Rezoning Transportation Analysis

Petition Number: 2023-045

Date	Description
7-26-23	First Review (IW)

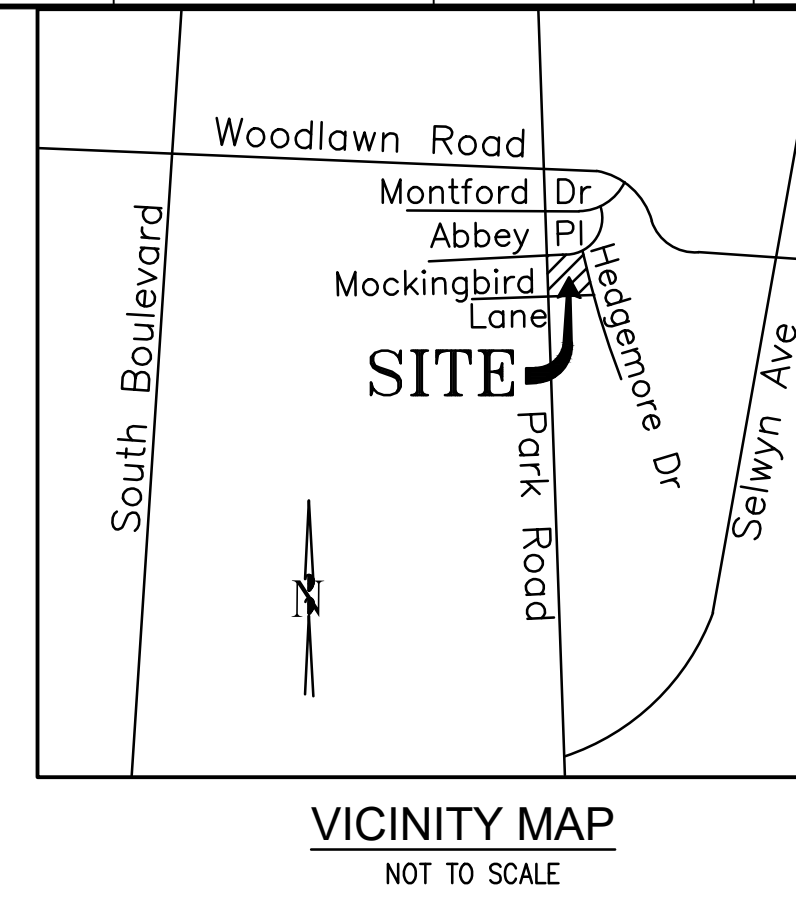
- a. The future location of curb and gutters are being shown accurately for all abutting roads as specified in the previously approved rezoning.

Label and dimension the curb and gutter from the centerline for each road on the site plan.
